25 April 2018

**Discharge of Planning Conditions under Appeal Ref: APP/C3810/W/15/3132744
Proposed Residential Development, Deans Yard, Orchard Close, Fontwell, West Sussex**

I write with regards to the above property and our clients' recent discharge of conditions application (REF: WA/19/18/DOC), in respect of which I note condition 4 has been refused on the grounds of 8 points as confirmed by the Planning Officer. In response to which we offer the following advice:

SILT TRAP

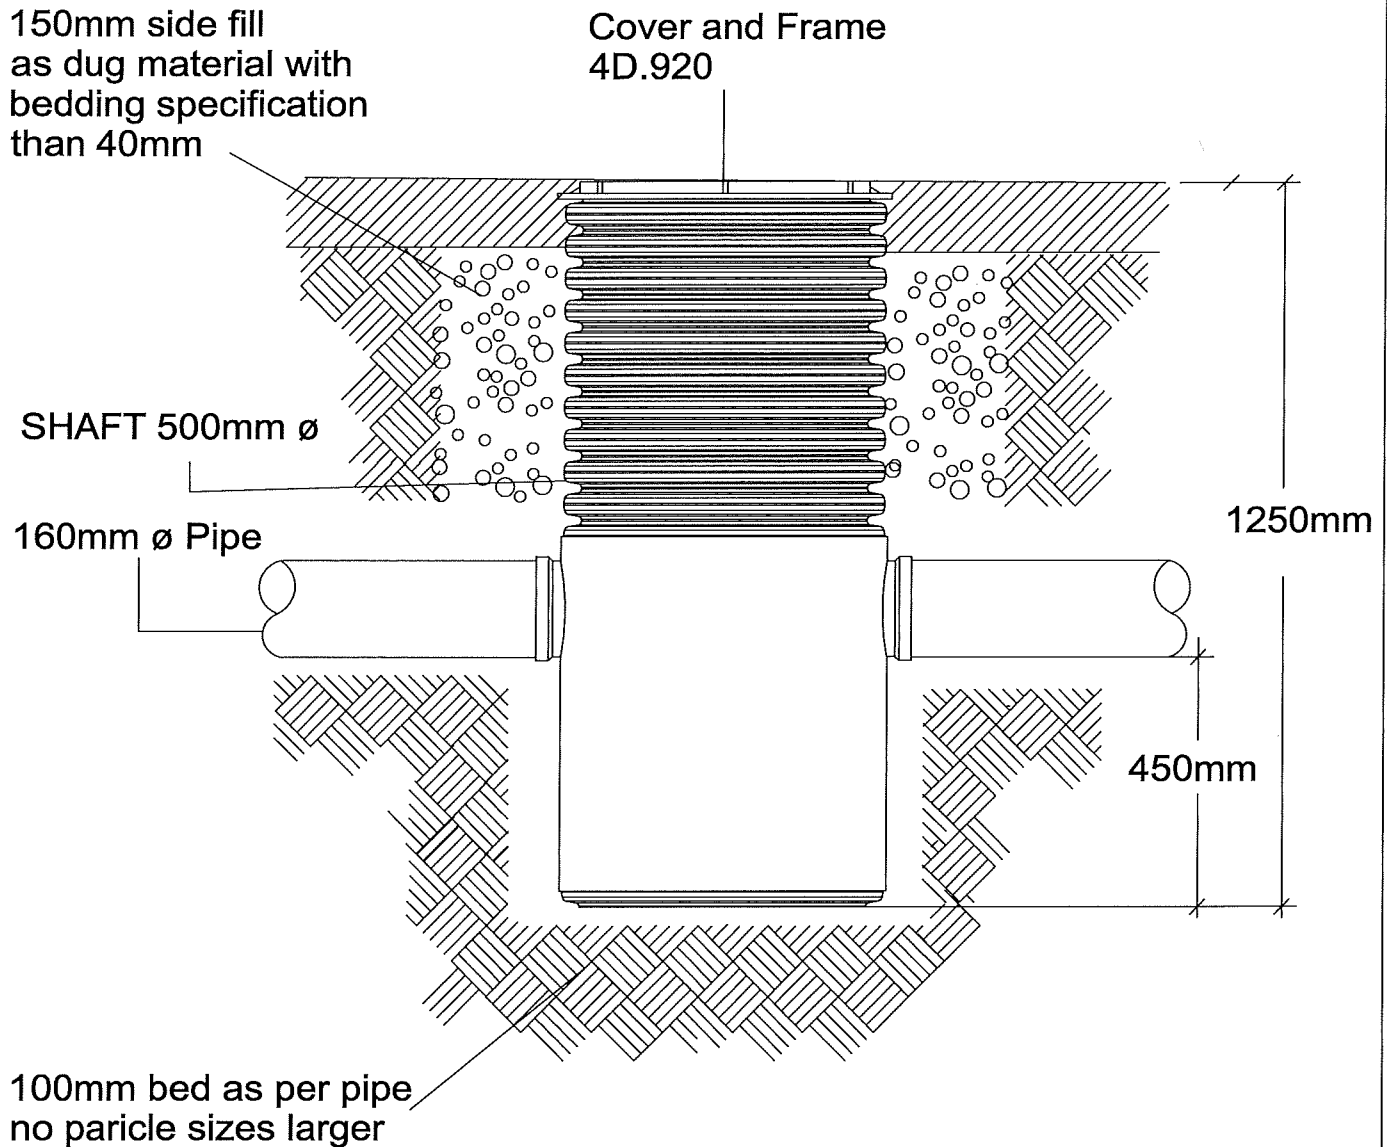
4. Please see attached details as provided by Arch Associates Civil Engineers
5. Please see attached details of Wavin manholes as provided by Arch Associates Civil Engineers & LMA's drawing 3113.PC01A
6. We have amended the soakaway locations by making them 1.7m apart, however note these have been calculated by a qualified engineer, therefore we would request on what basis your observations have been made.
7. Please see further attached drawing 3113.PC01A confirming the invert levels, cover levels, soakaway levels, pipe gradients etc.
8. It is my understanding our client does not own the existing drive & therefore it is unlikely to be reconstructed.

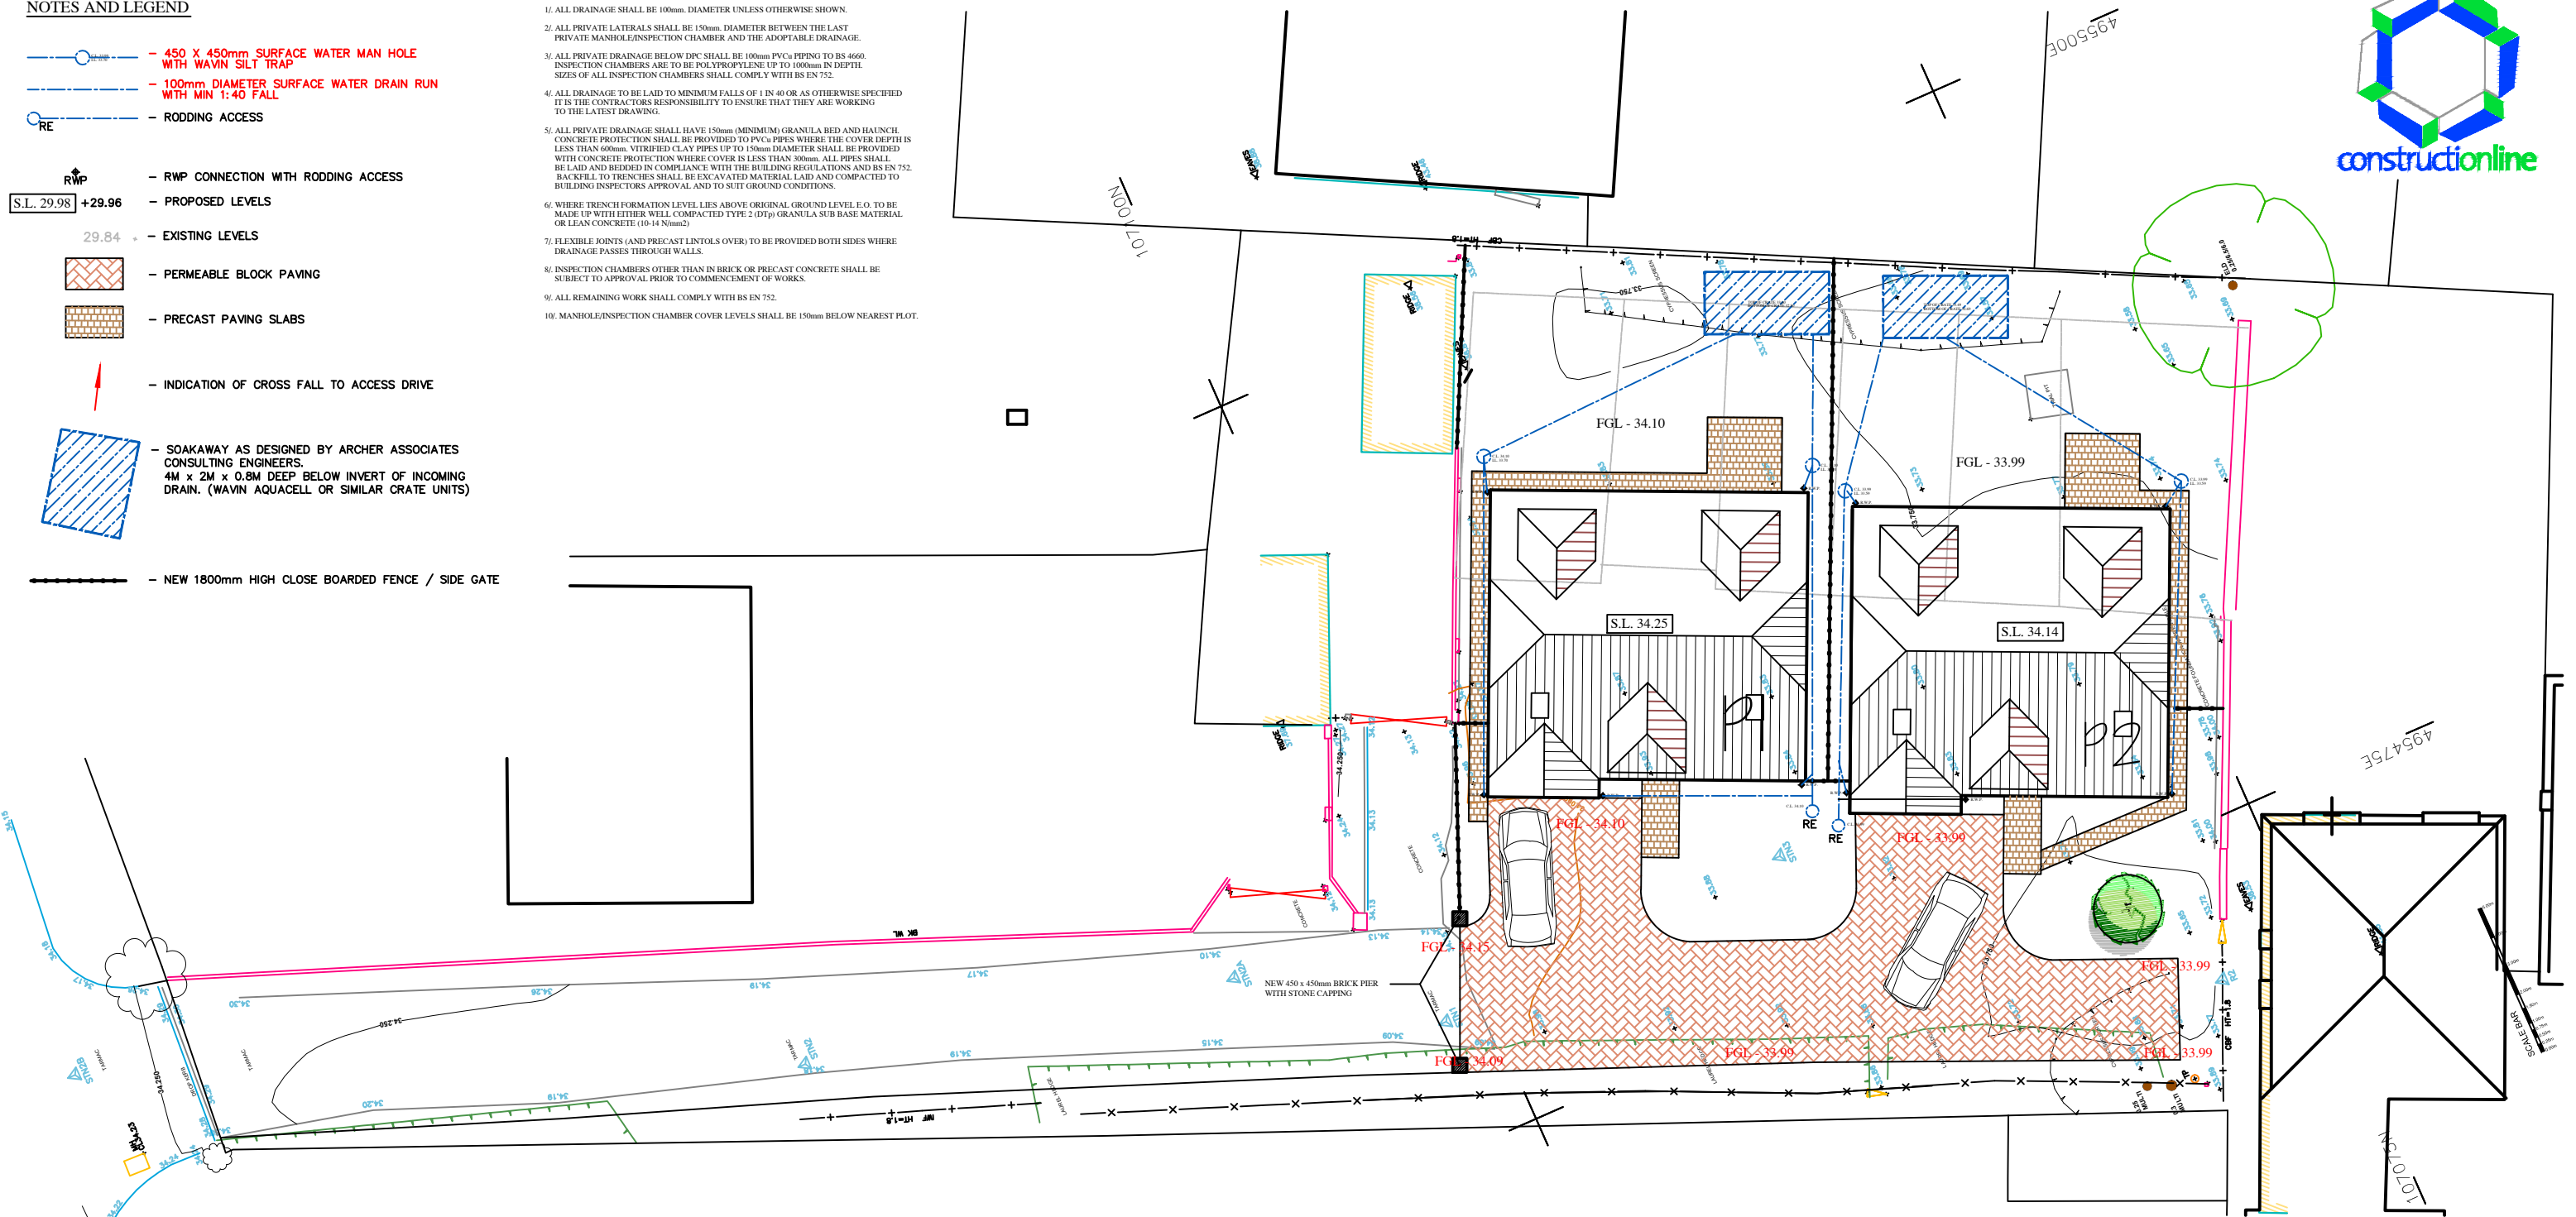
2. Please see further attached drawing 3113.PC01A confirming the proposed levels.
